2 November 2018

## Appendix A

### Record and Response to Submissions

Extracts from Government agency and authority submissions and submissions from the general public received in relation to SSD 18\_9347, and a response to each of these matters, has been outlined in the table below.

Stage 2 South Tower footprint

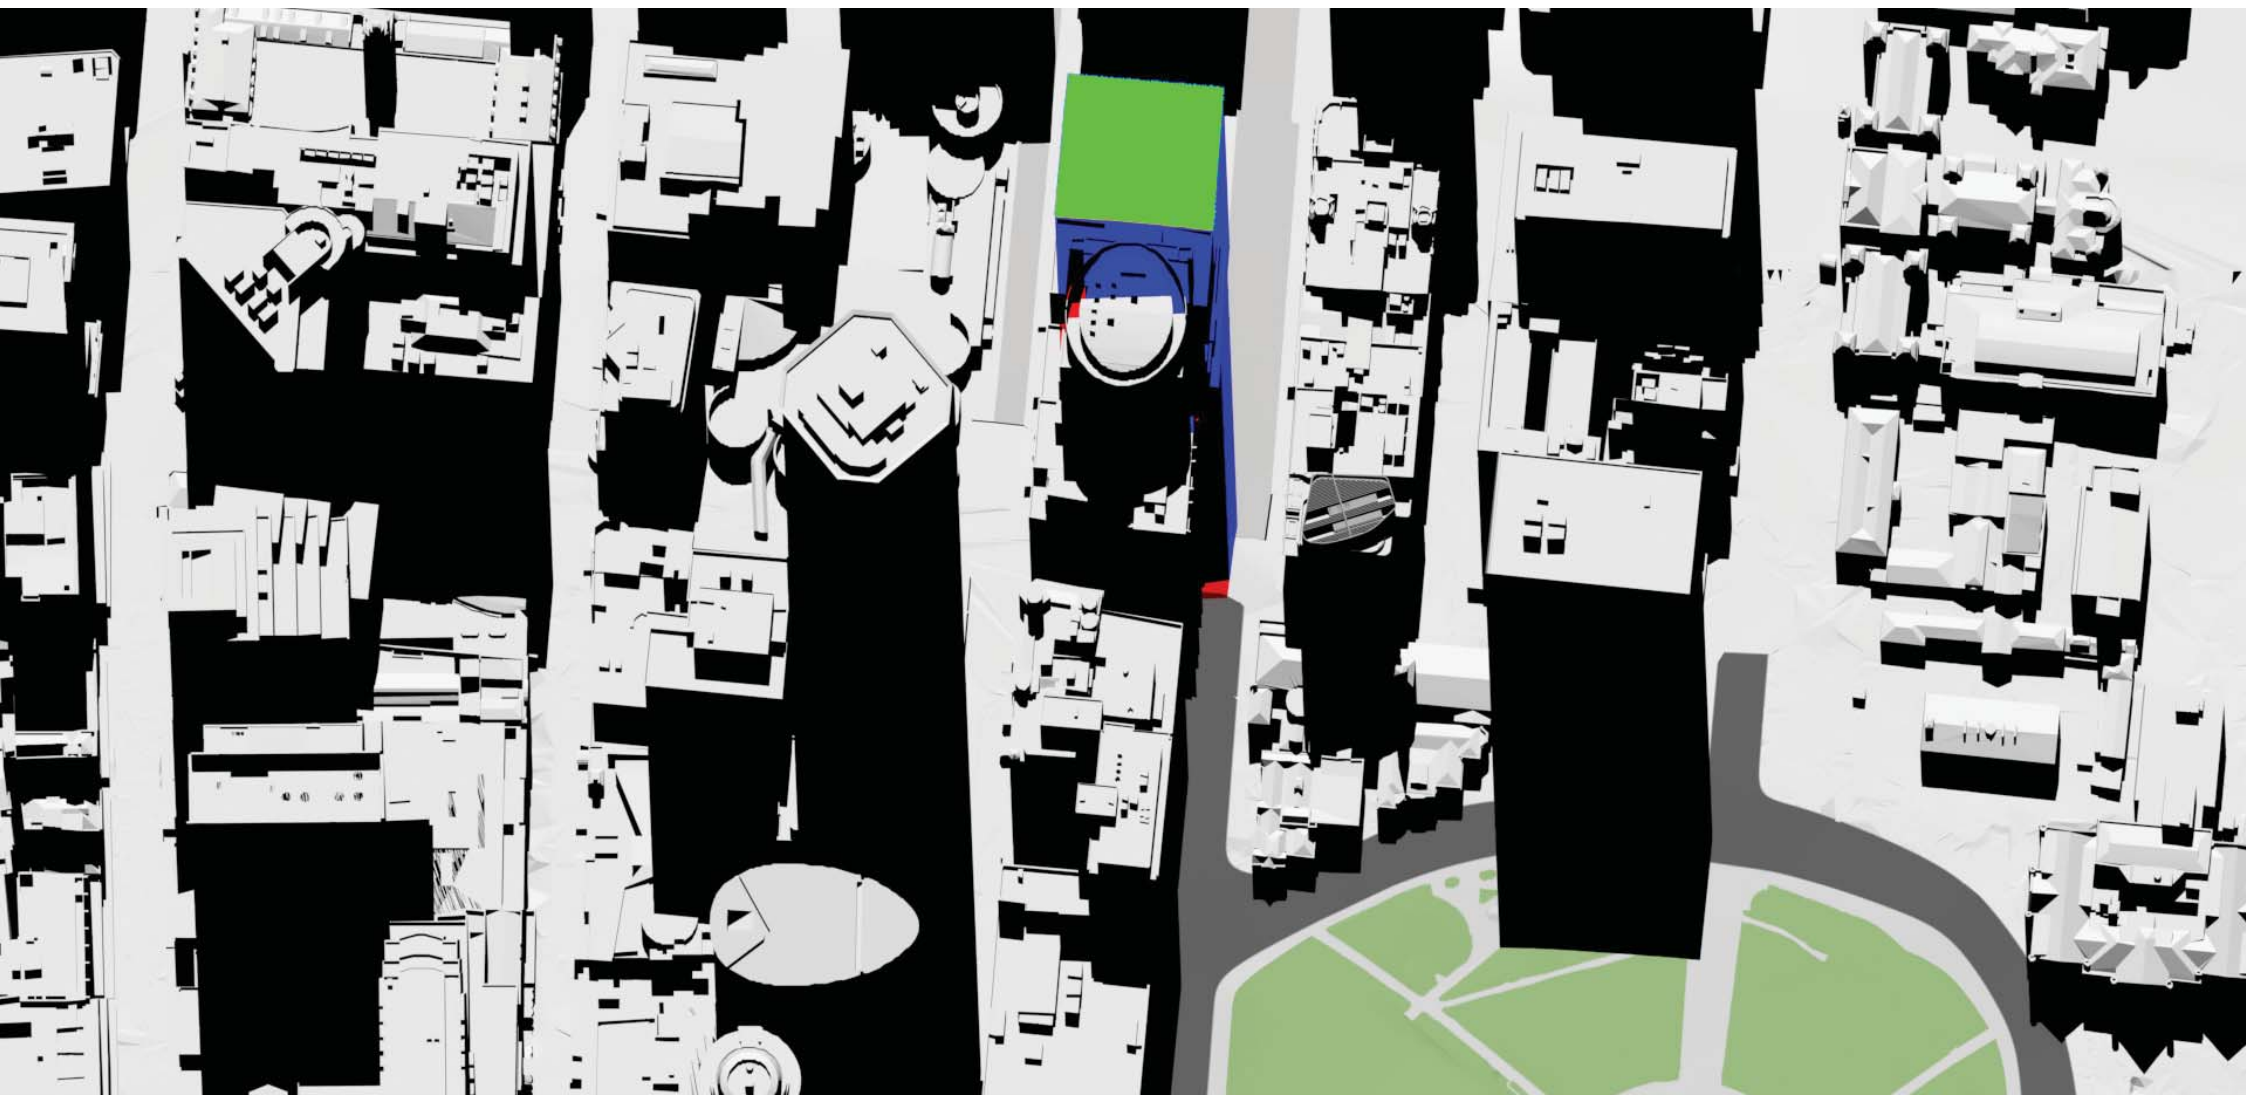
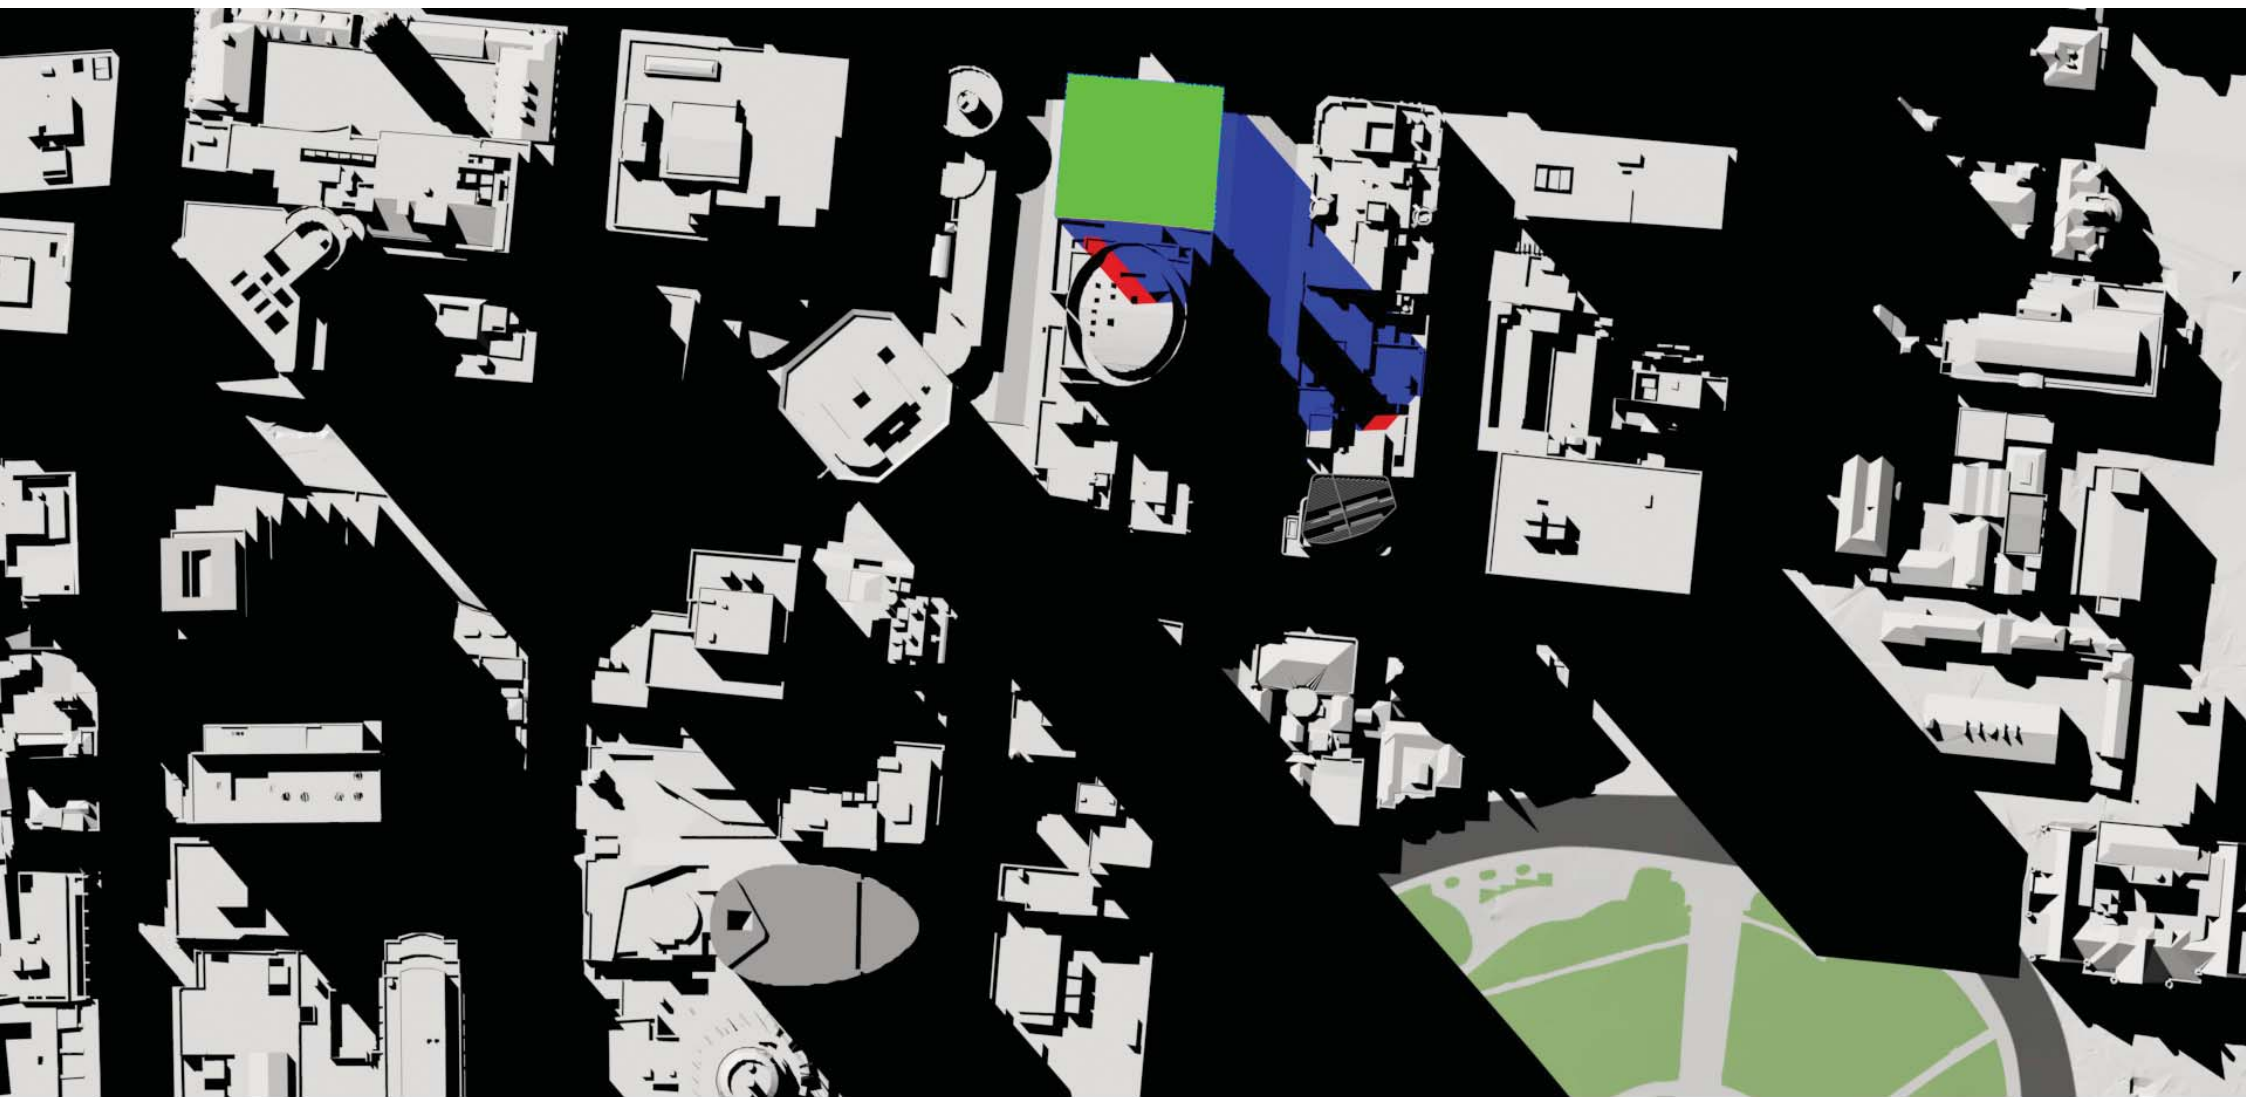
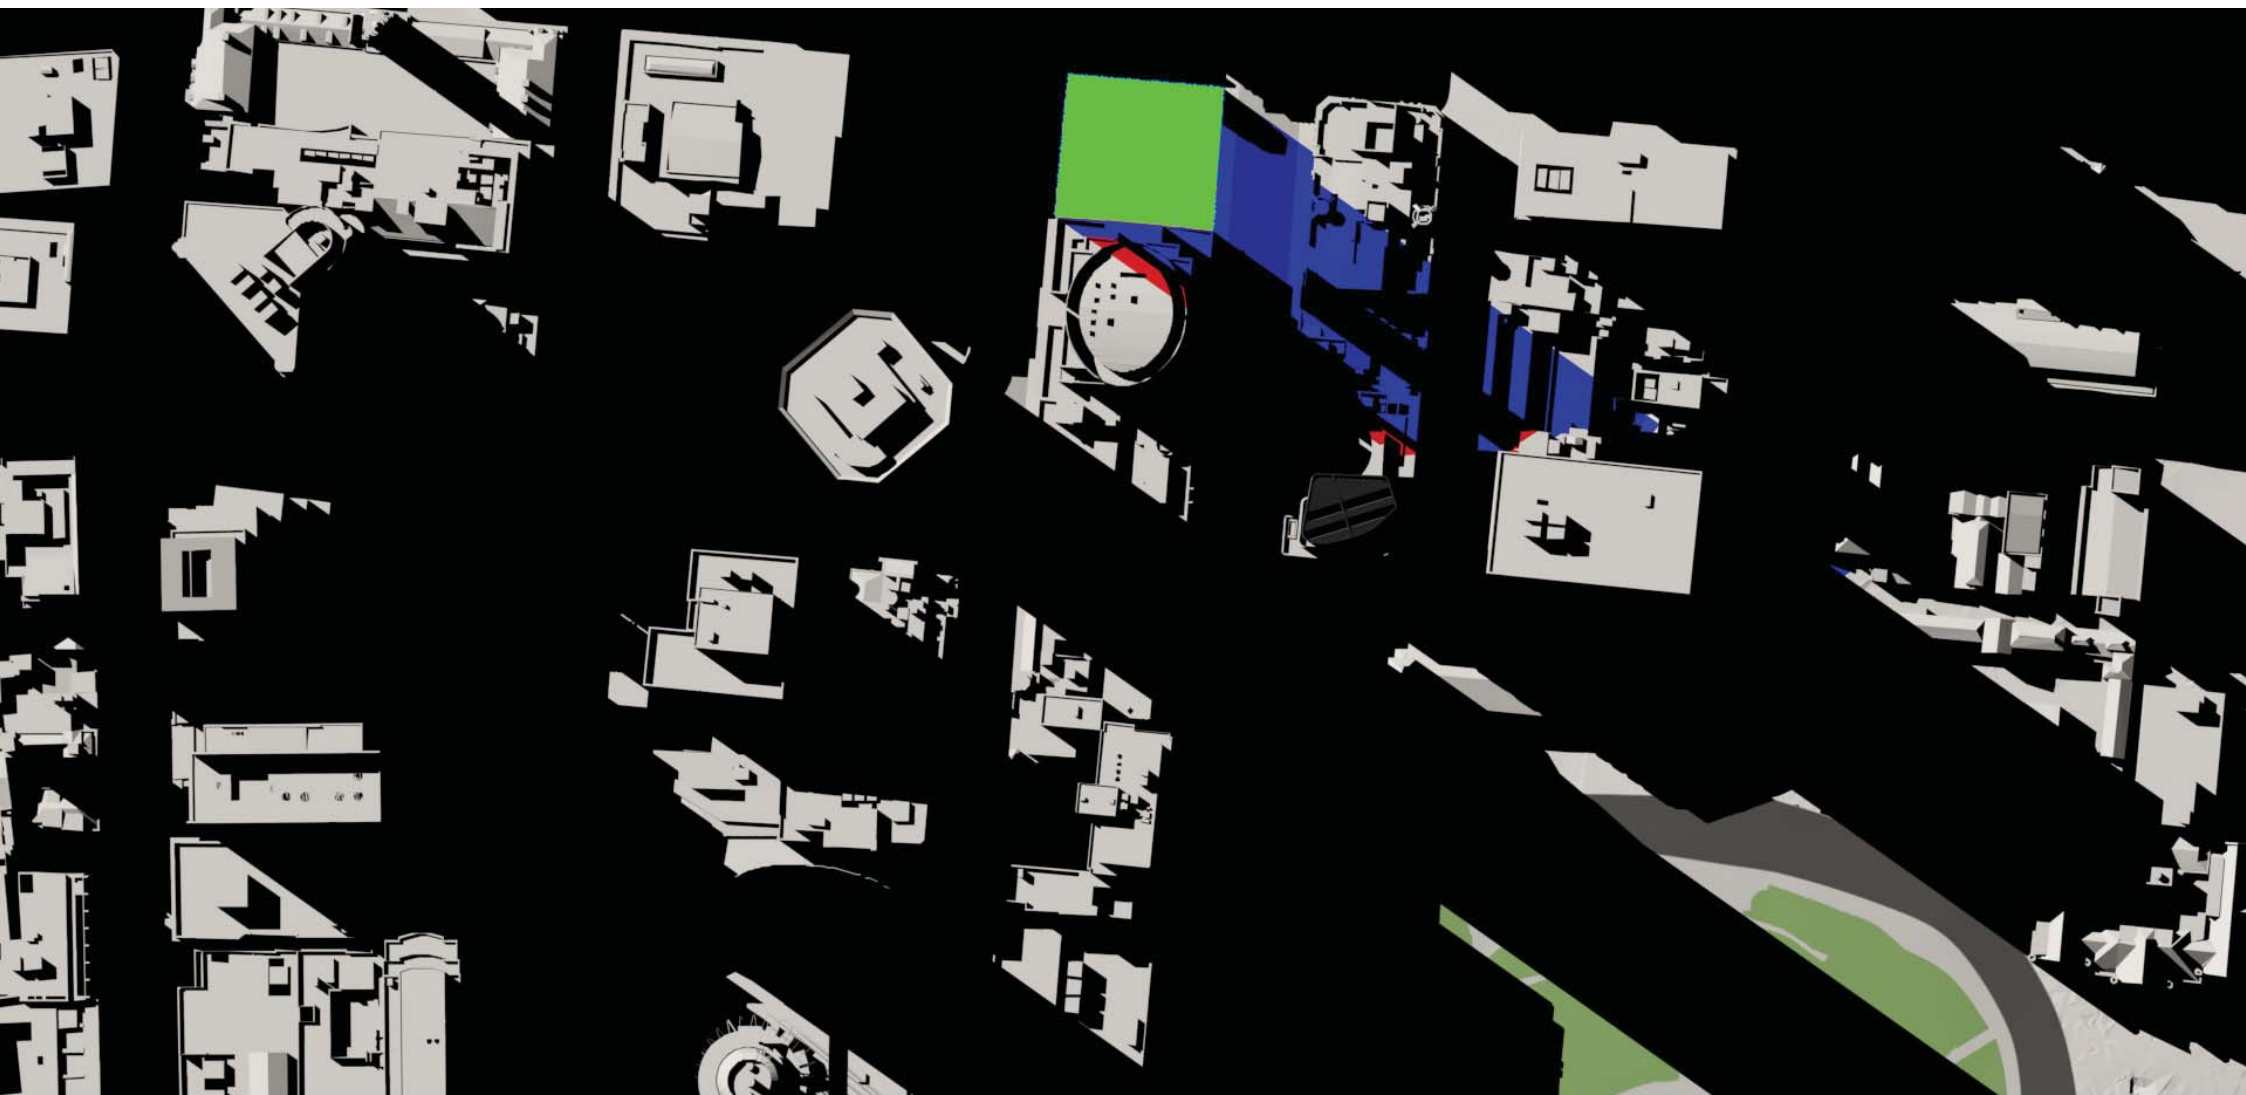
<p>In lieu of incorporating the recommendations regarding street frontage conditions along Elizabeth and Castlereagh Streets as part of the existing concept approval (SSD 8351), it is recommended that in amending the concept envelope and increasing the building mass of the south tower, building returns be incorporated in the southern corners of the envelope as a transition to the adjoining development to the south above the podium height. This would in part assist in achieving the outcome of the Independent Planning Commission's advice of reinforcing the importance of the urban character and integrity of Martin Place and the associated city blocks. A return of 8m x 8m is recommended for each corner for the building above a nominal 45m podium height.</p>	<p>The returns suggested in the City's submission would undermine the creation of a successful transition to the adjoining development to the south. The returns suggested would also undermine the distinct threshold condition being created by the proposed development that reinforces the uniqueness and legibility of Martin Place within the urban fabric of the city. The introduction of recesses in the South Tower has been previously considered and reviewed by both the Sydney Metro and site-specific Design Review Panel, and was not supported as the desired or ultimate outcome for the South Site.</p> <p>The introduction of recesses is not an appropriate design response for the following reasons (as detailed further in the covering RtS report and supporting consultants' reports):</p> <ul style="list-style-type: none"> <li>• The amended building envelope for the South Tower is consistent with the approved relationship between the South Site and the southern boundary. A zero setback to the southern boundary was approved under the Concept Proposal (SSD 17_8351) and formalised in the endorsed Consolidated Design Guidelines. The treatment of the building envelope to existing and future developments to the south was supported and remains unchanged in the Stage 1 Amending DA.</li> <li>• The introduction of 8m by 8m recesses at a height of 45m therefore does not relate to the existing development to the south, creating a potentially awkward built form relationship between the proposal and the adjoining and adjacent development. It creates a new setback and podium height that is not echoed in the existing development to the south, and limits the flexibility to redevelop land to the south with regards to podium height and pressures of the Sun Access Plane (SAP). This is detailed in the supplementary response prepared by Tzannes and included at Appendix B of the RtS.</li> <li>• The proposed zero setback to the southern boundary defines the edge of this threshold, and is important for reinforcing the legibility of Martin Place in the urban fabric. Including recesses in the façade would undermine this threshold condition and therefore undermine the ability of the development to provide a clear sense of arrival to Martin Place. This would have the effect of reducing Martin Place's differential or 'specialness' when moving through the city, and as such would not achieve the Council's desire to reinforce the 'importance' and 'integrity of Martin Place'.</li> <li>• The introduction of 8m x 8m recesses above the podium would reduce the area of usable floor space to 972m<sup>2</sup> of Net Lettable Area (NLA). This reduced floorplate impacts the ability of the South Tower to attract and accommodate large multi-floor occupants and premium global businesses, which in turn undermines the ability of the South Site to contribute to the long-term viability and competitiveness of the Sydney CBD.</li> </ul>

Extract	Response
	<ul style="list-style-type: none"> <li>Introducing recesses into the proposed South Tower building envelope will not result in any meaningful environmental benefits. This has been detailed in the technical studies that accompanied the EIS and approved Concept Proposal, and the RTS, which conclude there would be no recognisable improvement to wind conditions, overshadowing or views.</li> <li>The introduction of recesses to the building envelope would require a range of associated changes to the building and integrated station, as they impact on the structure of the building.</li> </ul>
<p>The Wind Environment Study prepared by CPP for the proposal indicates that locations around the site (17-19, 23-26) would experience increased wind speeds as compared to the existing concept envelope. As noted in previous submissions to the existing concept envelope, design options that retain the current comfort ratings (including the consideration of weather protection) should be considered.</p>	<p>The building envelope considered under the Stage 1 Amending DA does not preclude achieving a good pedestrian wind environment, and meeting the commitments of the Consolidated Urban Design Guidelines (as proposed to be amended) to create pedestrian standing environments at station entrances.</p> <ul style="list-style-type: none"> <li>All areas that were assessed remain suitable for their intended use in this section of the city, and as such the change to the comfort rating does not adversely impact the intended function of these spaces.</li> <li>The measured threshold wind speed is close to the boundary between two comfort categories in both locations, and as such even though the comfort rating has changed, the relative magnitude of the change is minor. CPP confirms that there is negligible difference in wind conditions between the approved and amended configuration.</li> <li>The results relate to the approved and amended maximum building envelopes and not the detailed design of the South Tower. Wind conditions are improved in the detailed design of the South Tower, as outlined in the Pedestrian Wind Environment Study accompanying the Stage 2 DA for the South Site (SSD 18_9326). This detailed analysis accompanying the Stage 2 DA confirms that the surrounding pedestrian environment complies with the relevant safety criteria, and that pedestrian comfort has been improved at every location when compared to the building envelope (other than one location, which still meets the desired 'pedestrian standing' criterion). Accordingly, the detailed design of the South Tower already largely achieves the objective of retaining or improving comfort ratings.</li> <li>The amended South Tower building envelope is also capable of achieving a 'pedestrian standing' criteria at the station entrance, which is identified in both the approved and amended Consolidated Design Guidelines as being a key aspiration for the development.</li> </ul>
